Address: 8 Snelsins Road Cleckheaton BD19 3UE

Application number: 2024/92237	
What is the application for?:	Erection of single storey rear extension with new proposed side entrance
Address of the site or building:	10, Snelsins Road, Cleckheaton, BD19 3UE
Postcode:	BD19 3UE

Group Plans and Elevations [id 1054049] 001C Floor Plans -

PROPOSED SIDE ELEVATION

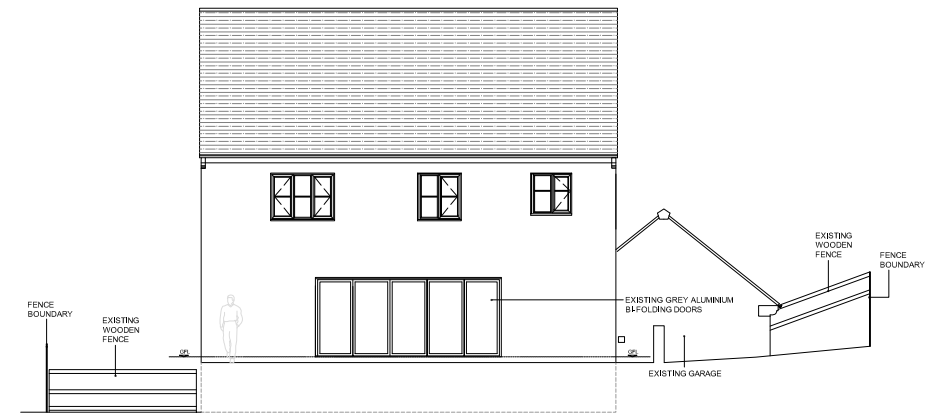
The side elevation where the proposed planting, steps and ramp are to be constructed, this needs to be amended. The boundary of Number 10 Snelsins Road does not run in line with the existing electric gate. The neighbouring property, 8 Snelsins Road boundary falls in this area outlined on the planning application.

PROPOSED SITE PLAN IN RELATION TO NEIGHBOURING PROPOSALS

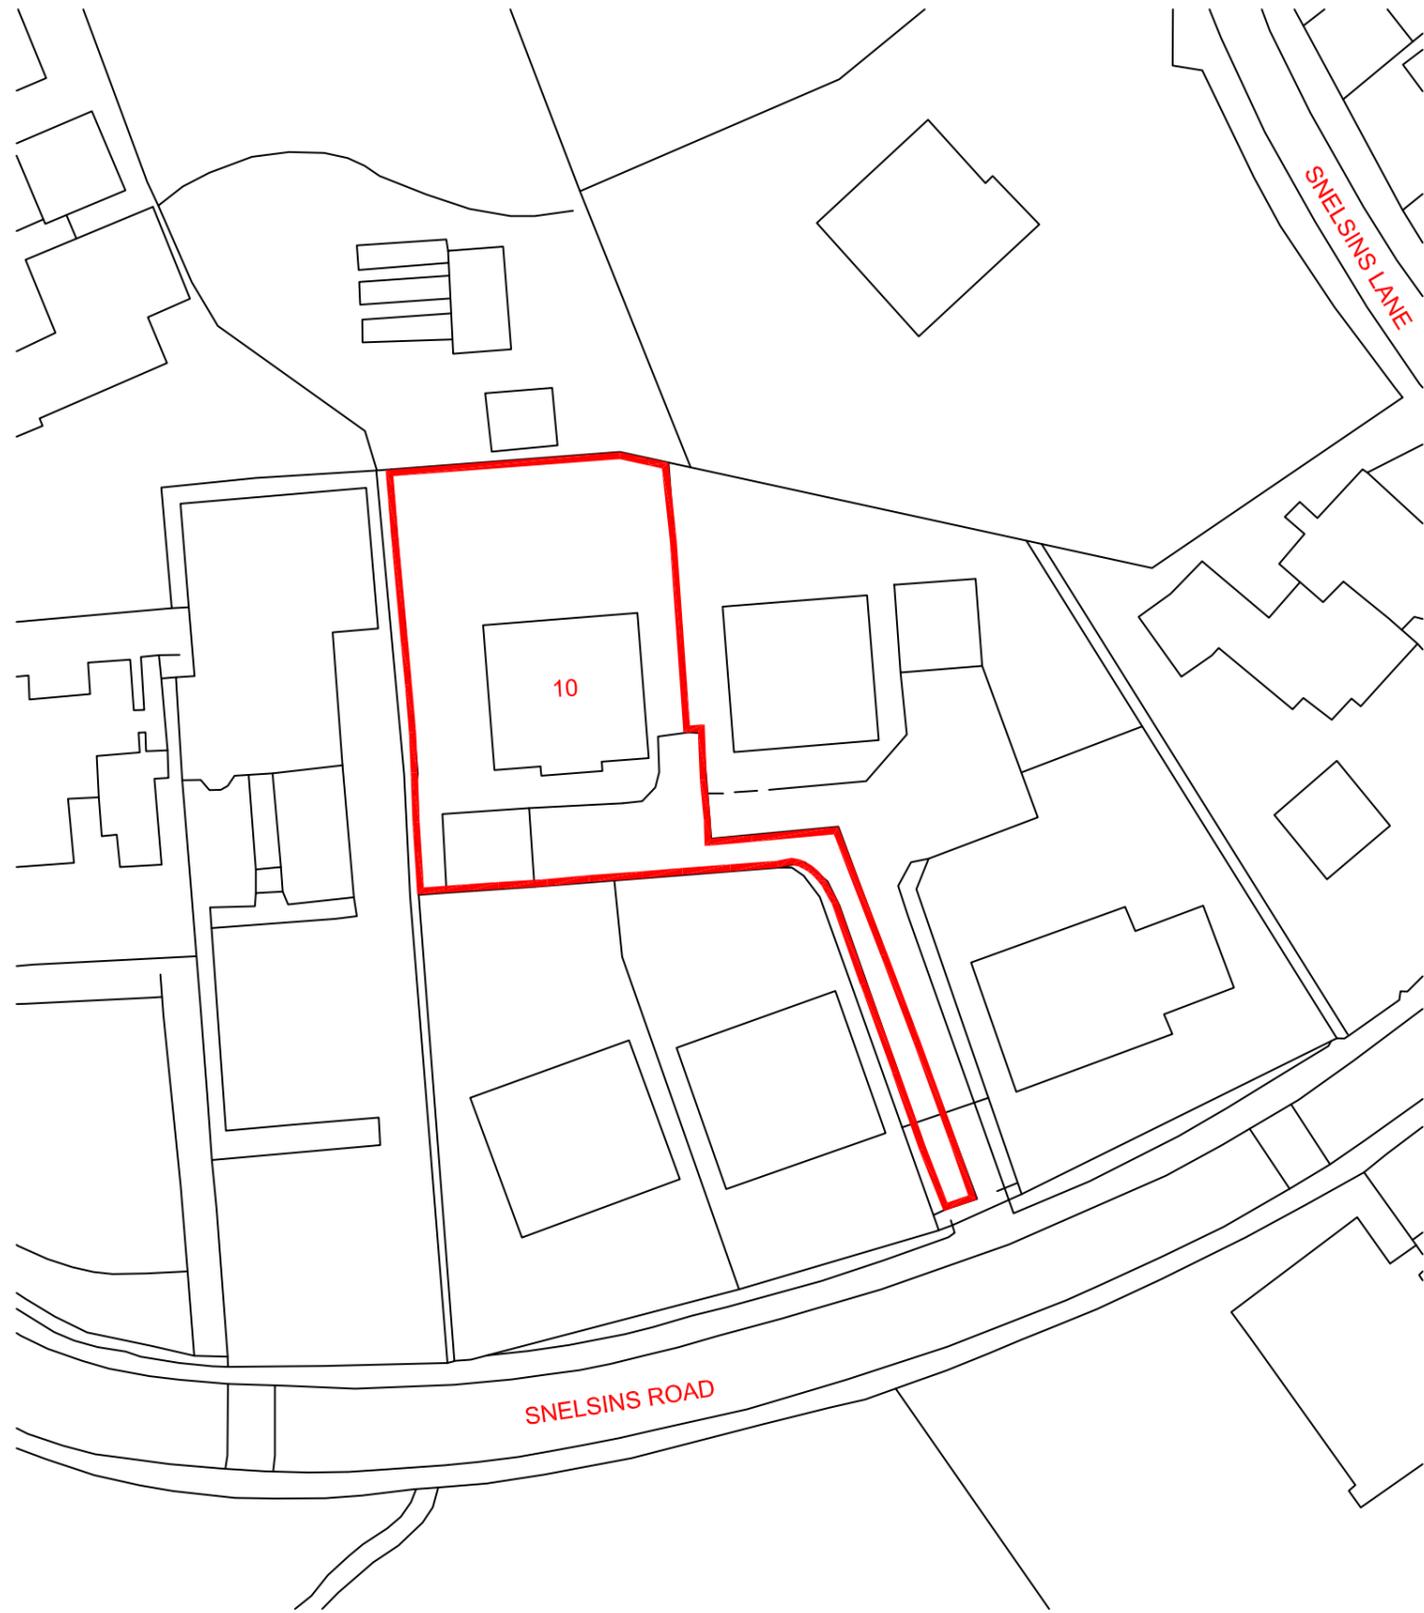
Both the existing and proposed ground floor plan are incorrect in respect of the boundary lines to the neighbouring property.

The application does not indicate where additional drainage will be placed to mitigate for the water surface run off, from the proposed new steps, ramp.

Number 10 stands elevated to number 8 Snelsins Road. With the existing grassed area and soil to be removed for the new steps/ramp, this excess rain water needs an adequate drainage system to prevent water run off into the neighbouring property.
